Please ask for: Nicola Moore
Email: nicola.moore@arun.gov.uk
Telephone: Ext 37944
Our Ref: FG/218/21/CLP
Your Ref:
Date: 24th December 2021

Lawful Development Certificate for a Proposed Use or Development

Development: Lawful development certificate for proposed sand and cement render of the external walls of the bungalow and then paint the completed render a pale grey or white colour.
Location: 4 Laburnum Close Ferring Worthing BN12 5EJ

DWG NO 994/02 REV. A

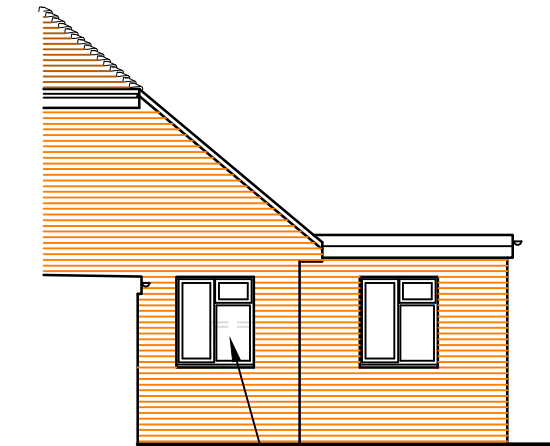
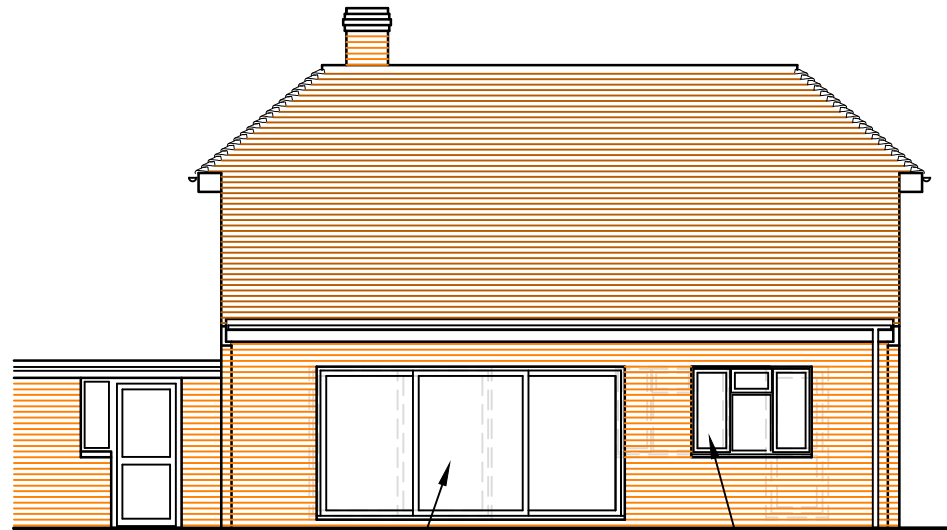
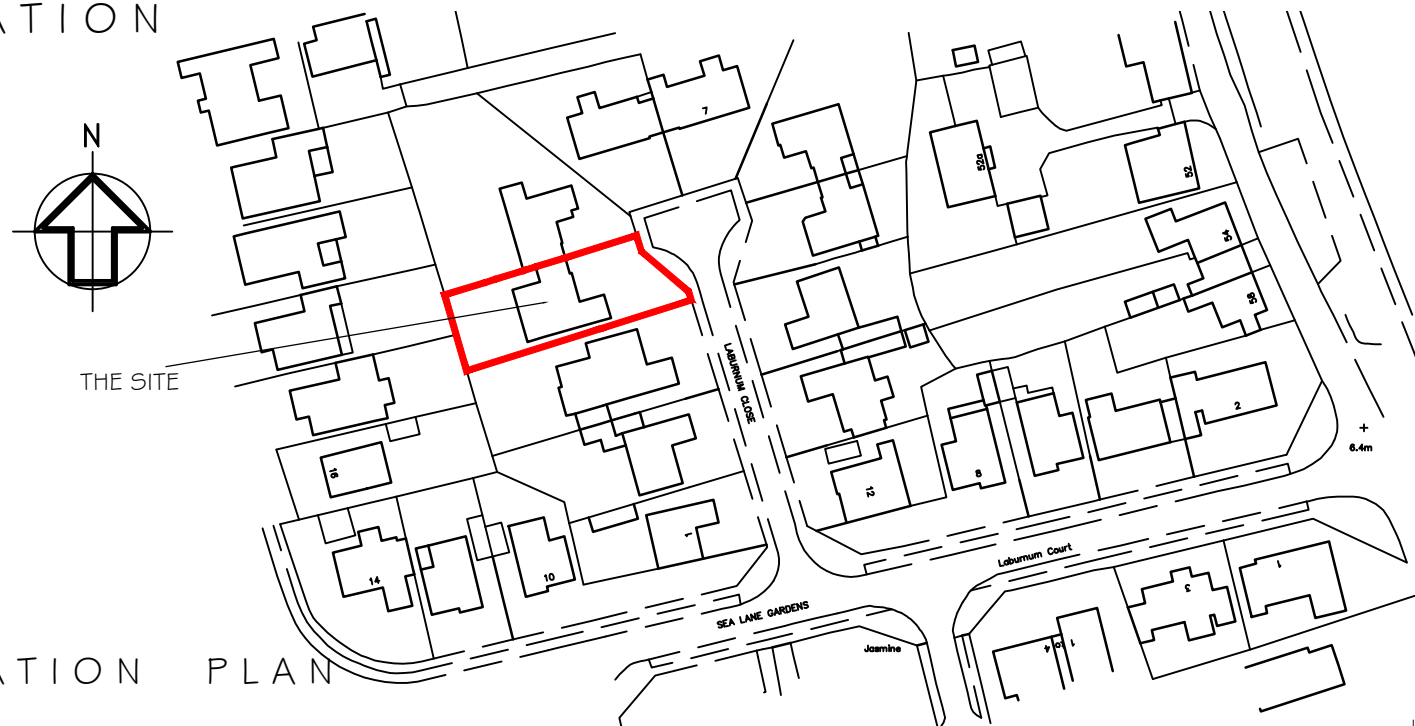
Please amend the proposed elevations to include the proposed external works.
